**WEST SUSSEX COUNTY COUNCIL
STRATEGIC PLANNING CONSULTATION**

SUBJECT: LU/177/14/PL - Demolition of original dairy distribution depot and construction of 8No. dwellings and ancilliary works. Resubmission following LU/298/13. This application may affect the Character and Appearance of the Littlehampton (East Street) Conservation Area.

The Old Dairy behind, 3 & 5, Church Street, Littlehampton, BN17 5EL

CLIENT	Graham Nicolls Limited		
PROJECT	The Old Dairy, Little Hampton		
TITLE	Fire Tender accessing the site, turning and egressing		
DRAWN BY	GPW	CHECKED BY	GPW
DATE	16/12/13	DATE	4429/201
SCALE	1:250 @ A3	SCALE	4429/201
		SCALE	B

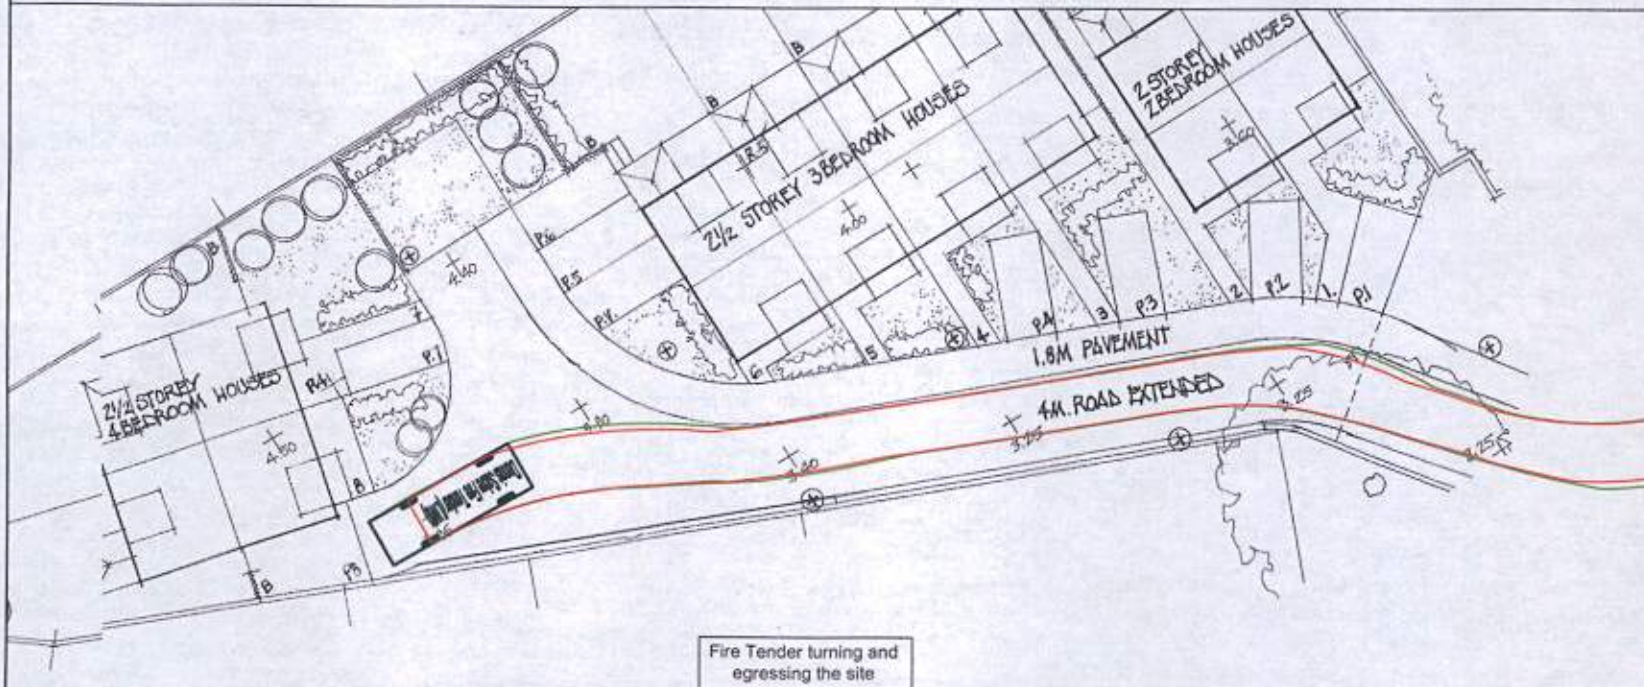
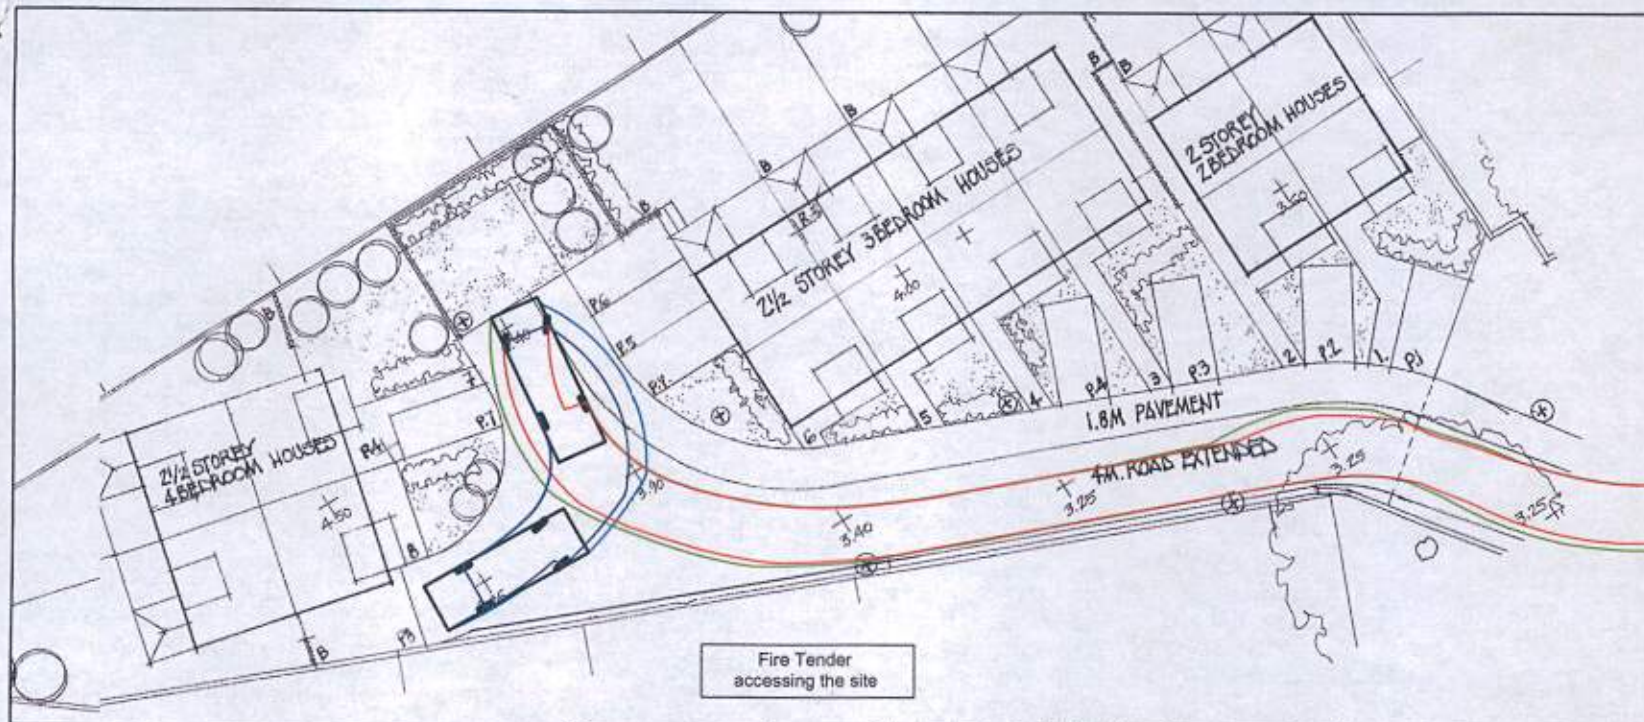
1. Swept paths for a refuse vehicle. The turn into and out of the access has not been shown in the swept path drawings submitted. We need to know that large vehicles can turn into the access safely from Church Street. If they can't alternative methods for refuse collection will need to be discussed with the local waste authority. MfS recommendations regarding waste collection vehicles should be considered. A minimum street width of 5m is recommended. Cul-de-sacs should be no longer than 20m, and a maximum reversing length of 12m. Waste collection vehicles should also be able to gain access within 25m of the waste storage point.

SITE PLAN WITH DRAFT LEVELS
 PROPOSED RESIDENTIAL DEVELOPMENT
 THE OLD DAIRY, CHURCH STREET, LITTLEHAMPTON, SUSSEX.
 GRAHAM NICOLLS LIMITED, DESIGN + TECHNOLOGY, TEL/07990 522709

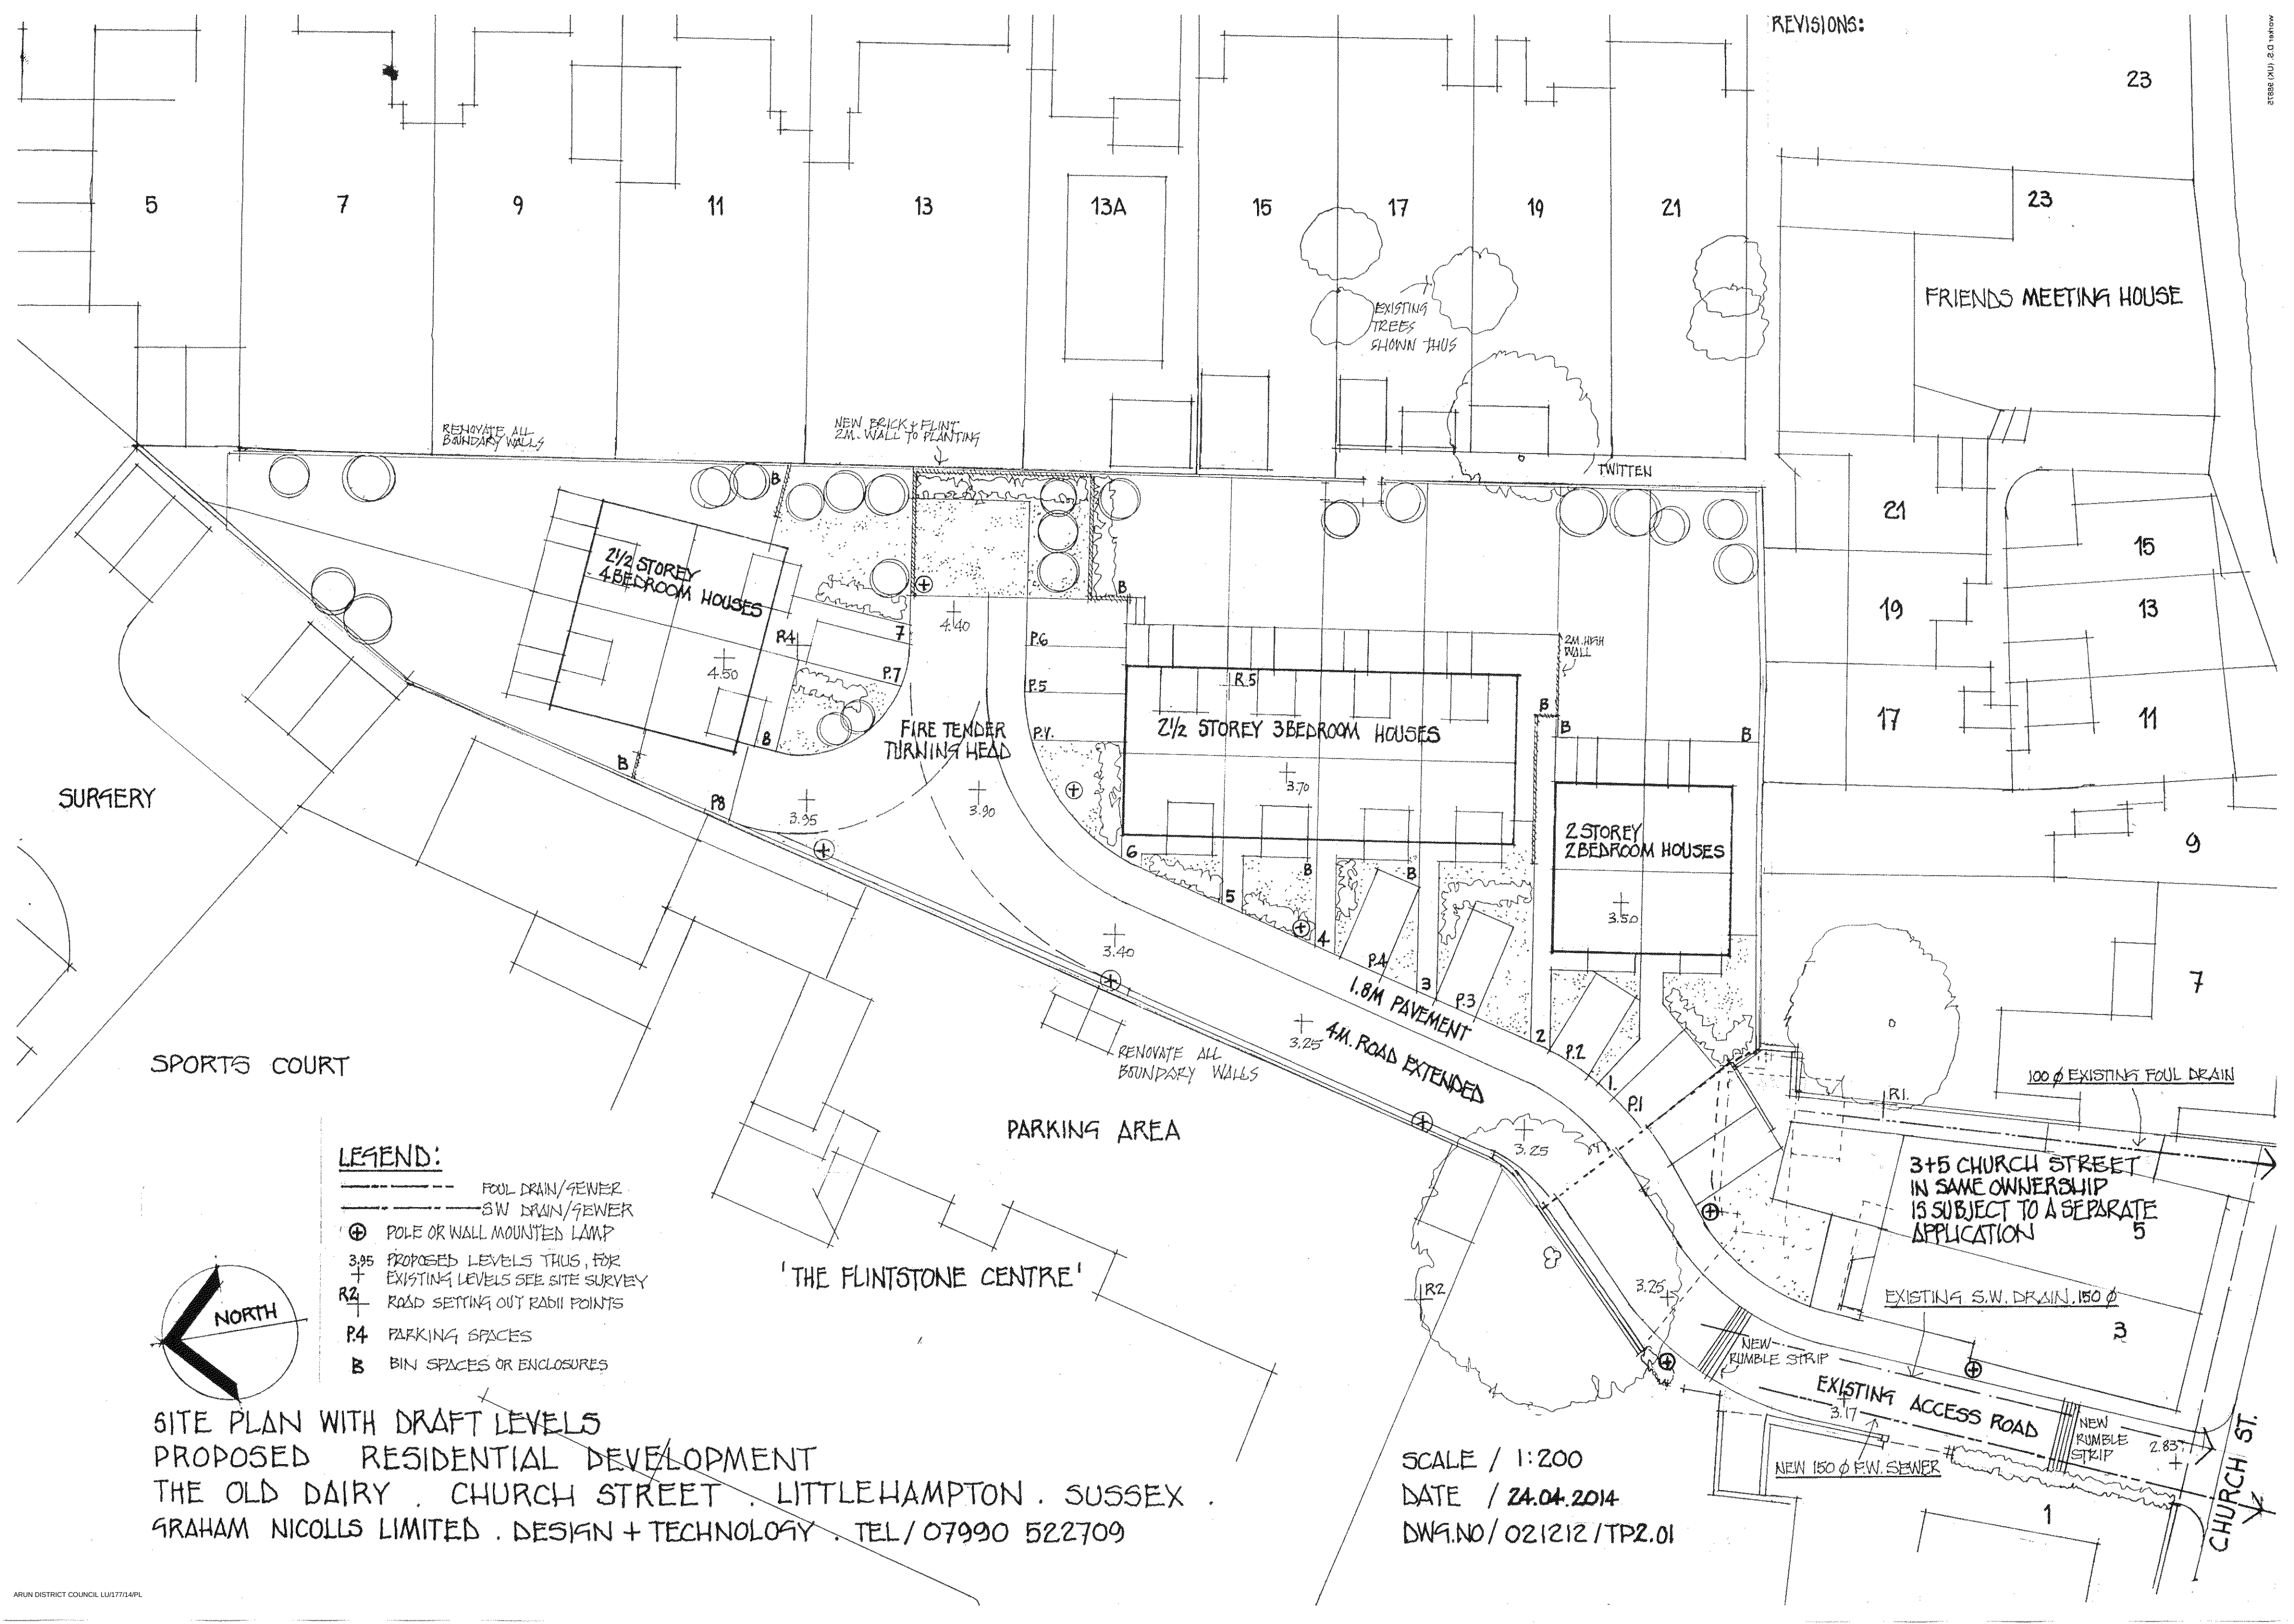
2. The developments car parking strategy provides one space per dwelling, and one additional visitor space. This has been compared against the WSCC car parking calculator which suggests that for this number of dwellings 8 allocated spaces and 6 unallocated/visitor spaces should be provided. It would appear that the proposed parking strategy falls below the maximum standard; however due to the sites constraints the number of parking spaces that can be provided is limited.

4. Internal Layout – the 4m wide carriage way looks narrow and the indication that a footway will be introduced narrows this even further. The junction radii seem tight to the extent that a refuse or emergency vehicle may not be able to turn into the site without overriding footways. The existing road layout seems short and servicing could possibly be carried out on the Church Road without the need to enter the site, which is different to the proposed. There is no connectivity between the existing footway along Church Street and the footways from the site. A shared use layout would allow for a wider carriageway width to allow for the passing of cars, without having to mount the footway. It is unclear if plots 3 & 5 will have their own driveway access onto Church Street.
